Robert **Bird** Group

Civil & Structural Engineering Review
Report, of

**CBD and South East Light Rail (CSELR)
Project
Environmental Impact Statement (EIS)**

Document No.: 13895 – RBG – ATC - 001

RRR STOP

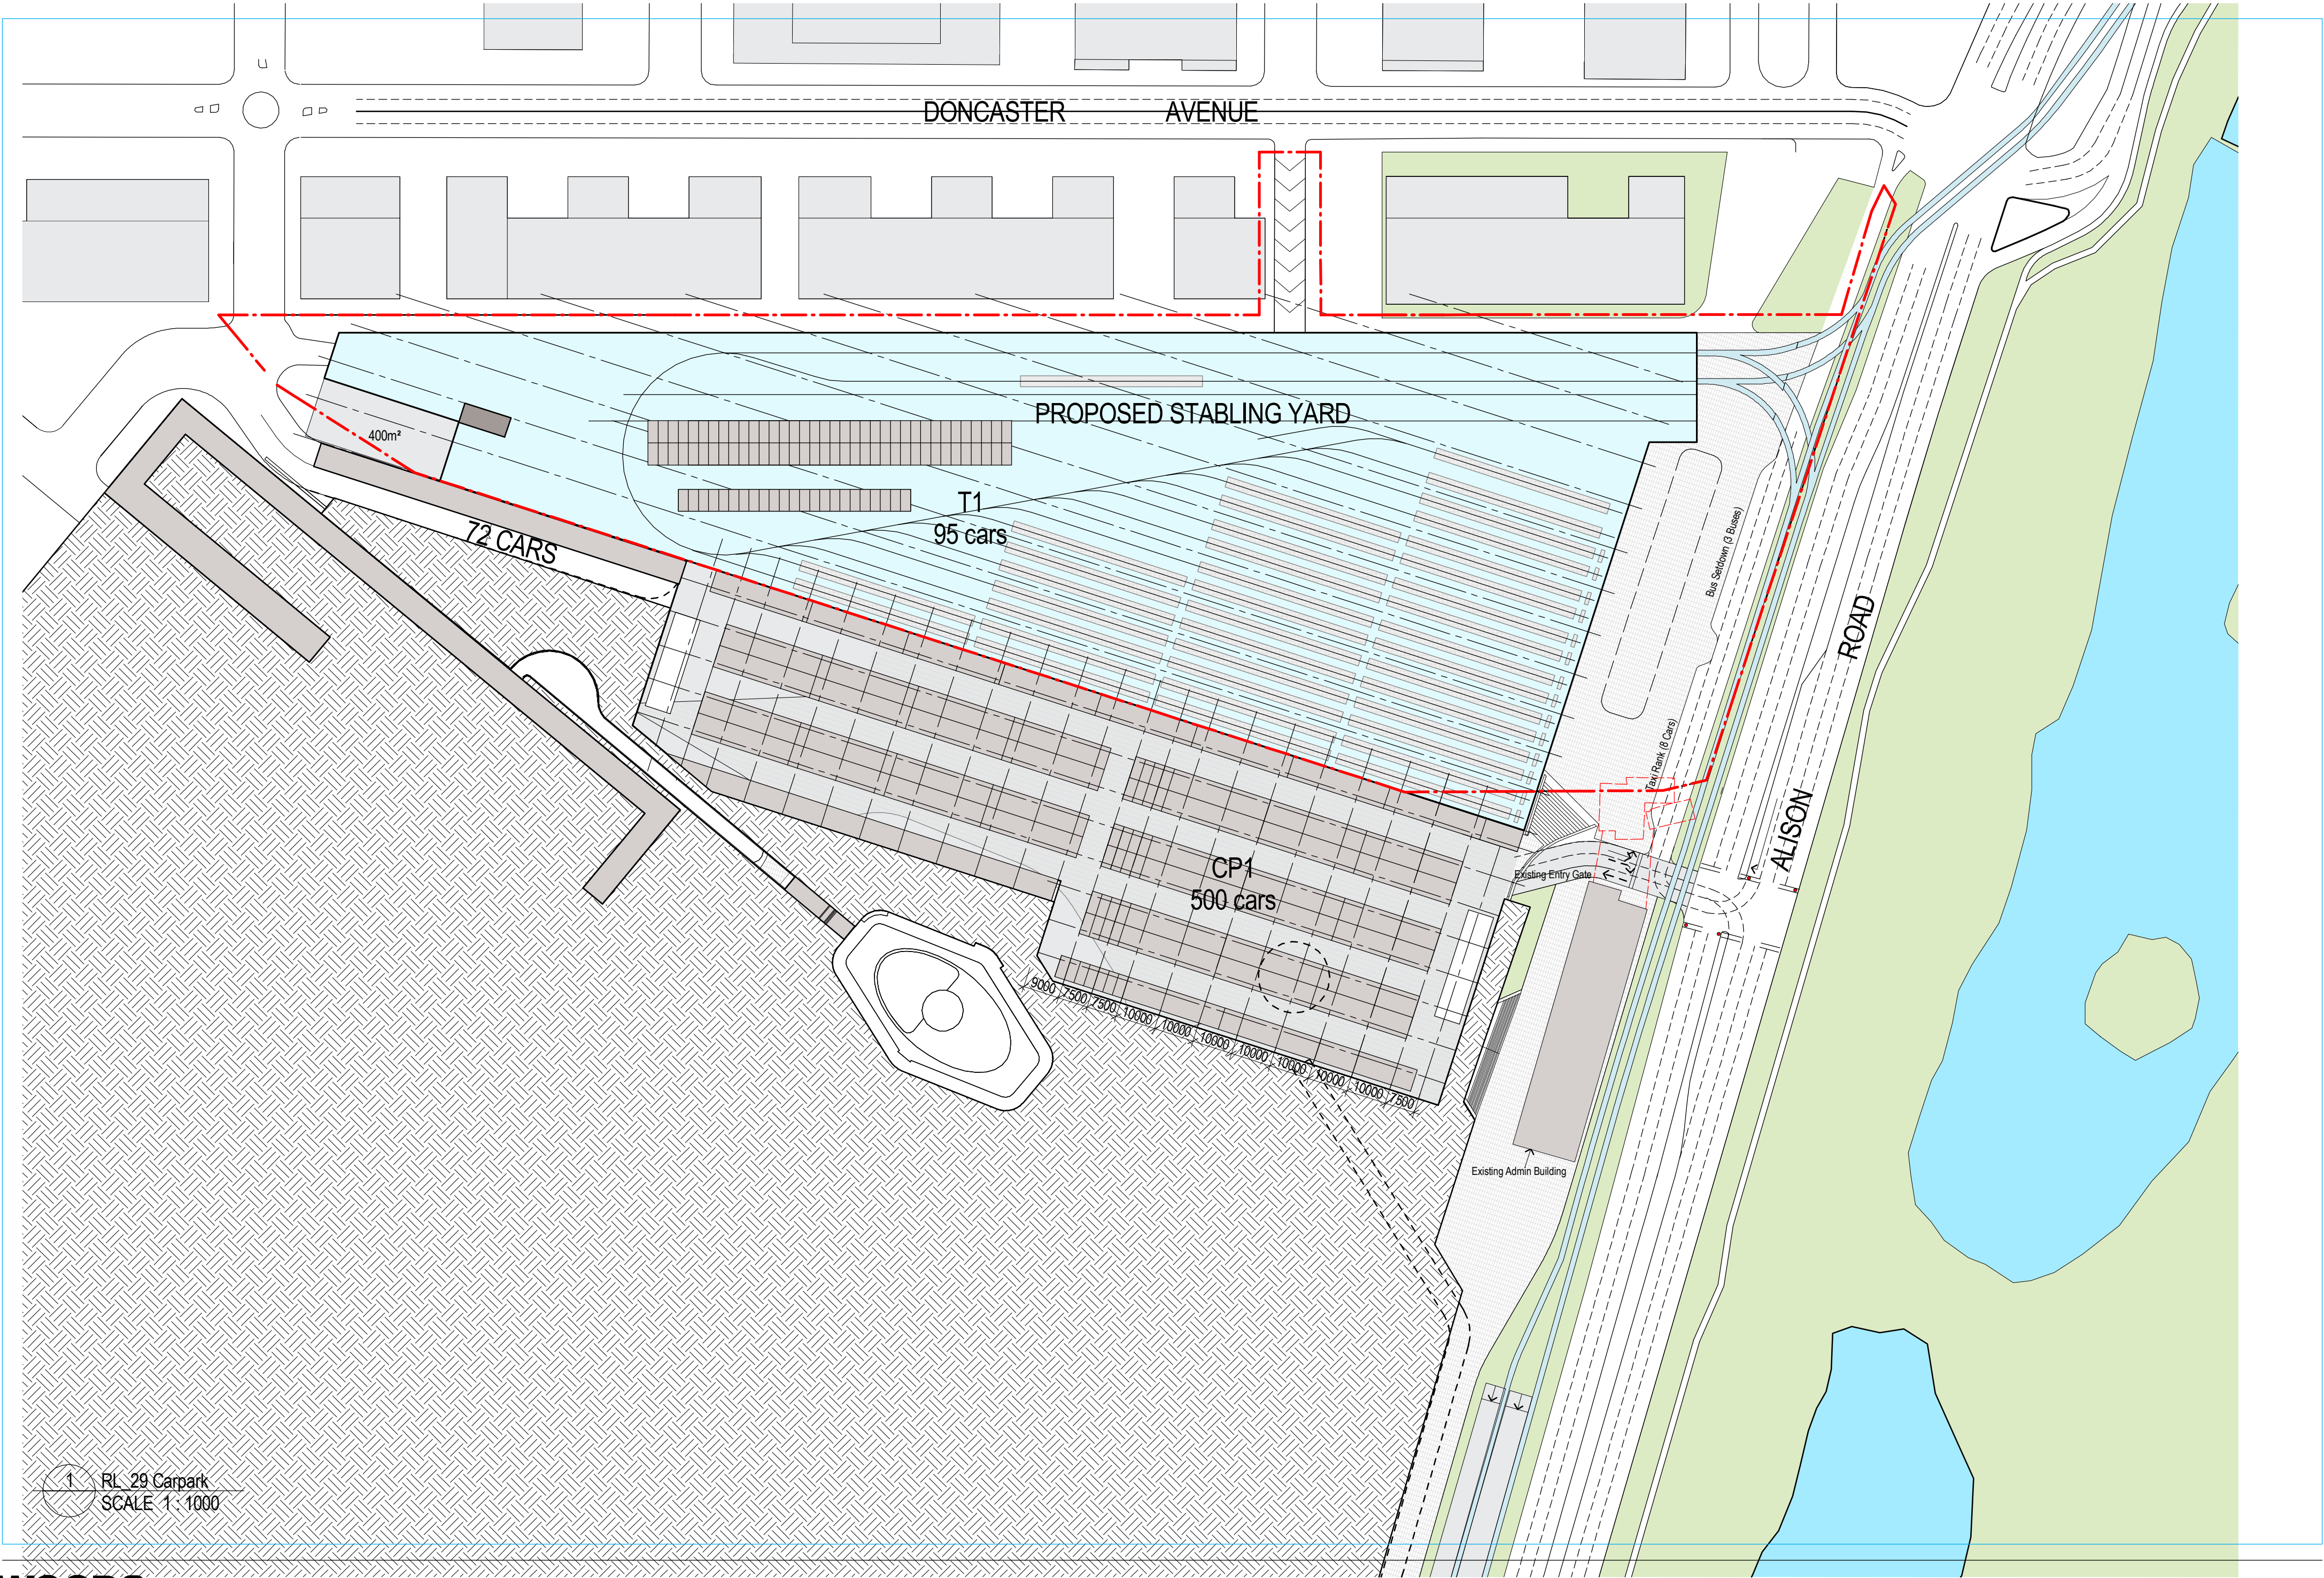
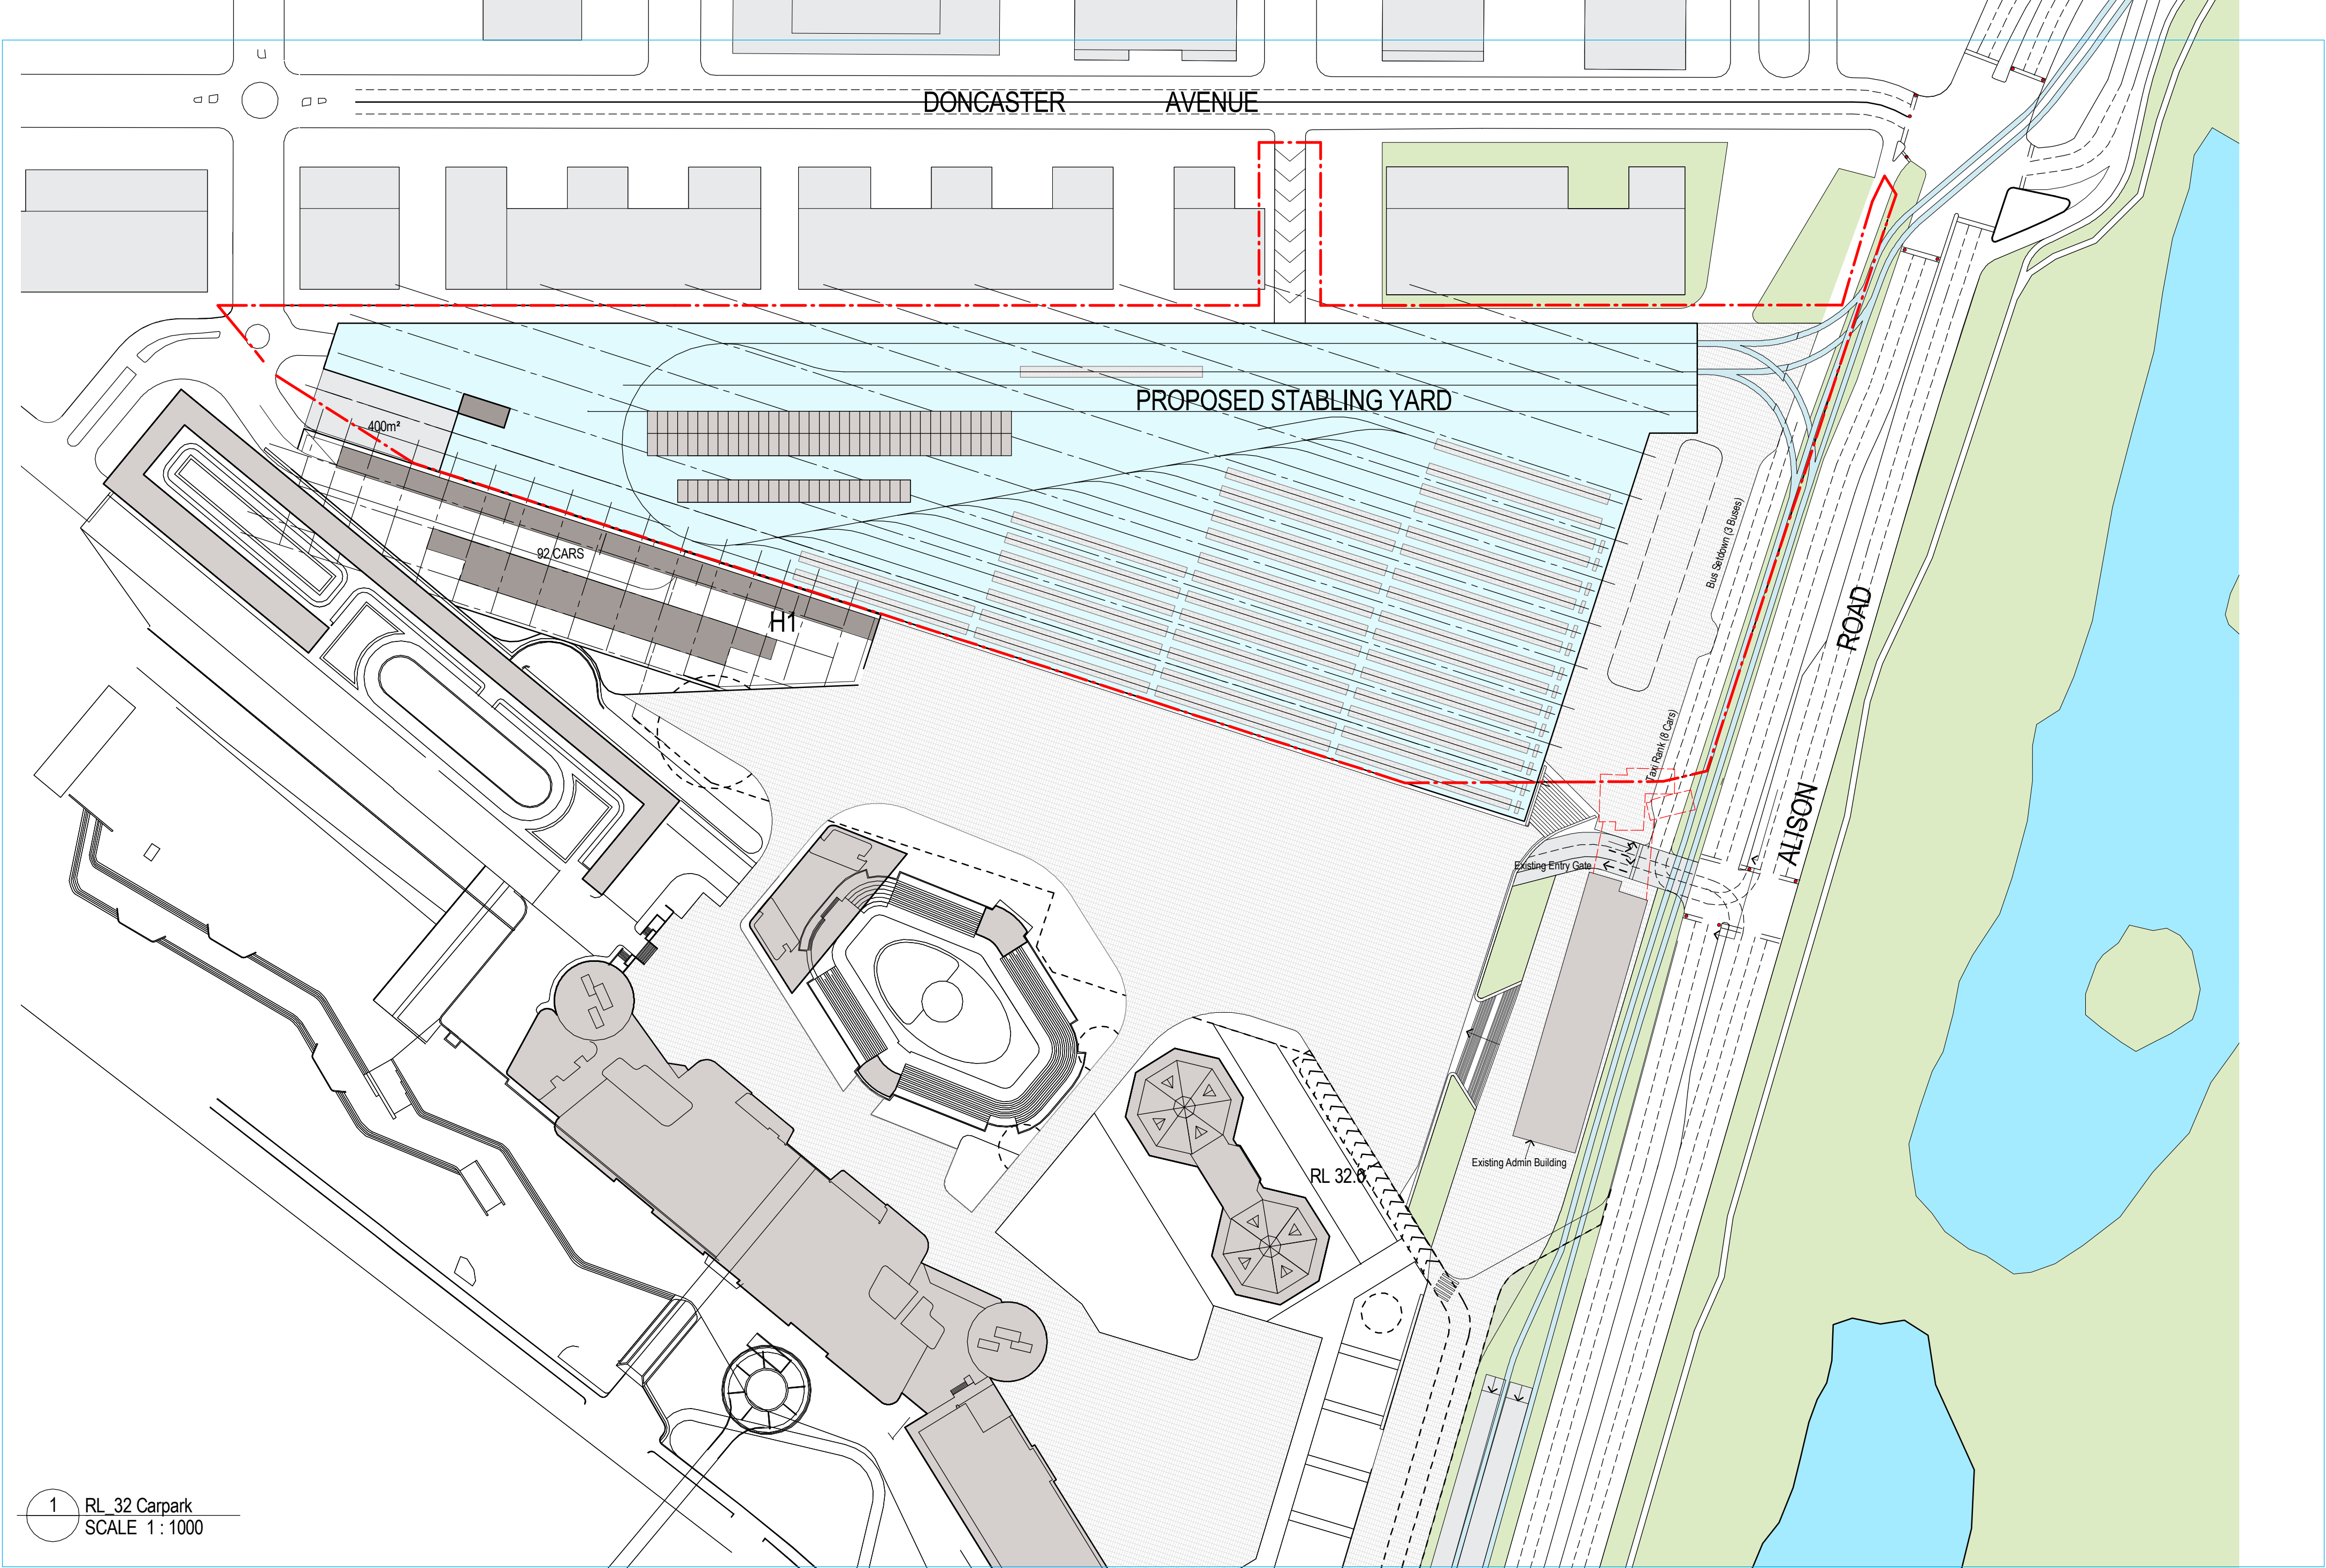
The alignment of the CSELR in the vicinity of the RRR Stop passes very close to the existing ATC Administration Building. The proposed alignment requires demolition of the existing brick wall outside the Alison Road frontage of the building, removal of trees, and impacts on an awning and services.

Other than the impacts noted above, with the alignment passing a few metres from the building, consideration should also be given to

- Vibration impacts on the existing structure and occupants.
- Noise impacts on occupants.
- Pedestrian safety for occupants exiting the building with the rail passing close to the front door.

The use of noise/vibration attenuating trackform should be considered in this area and any areas adjacent to buildings or stables should be utilised to minimise impacts.

EIS Technical Paper 11 – Part A, page 18, notes that noise catchment area NCA05.2 as being a minimum distance of 4m to nearest receptor building façade. Preliminary CSELR alignments would indicate that the CSELR is closer than 4m to the ATC administration building. Technical Paper 11 notes the use of high-resilience trackform to mitigate impacts of ground-borne noise on sensitive receptors. The extracts below from the EIS nominate the proposed trackform options to reduce noise (and potentially vibration) effects on receptors. The Alison Road alignment, including the ATC administration building frontage, is noted as being Standard Trackform. Consideration has been given to the future hotel within the RRR, however consideration should be given to provided noise and vibration attenuating trackform in front of the ATC administration building, and other potentially sensitive receptor areas on the RRR boundary, including existing and future horse stabling.
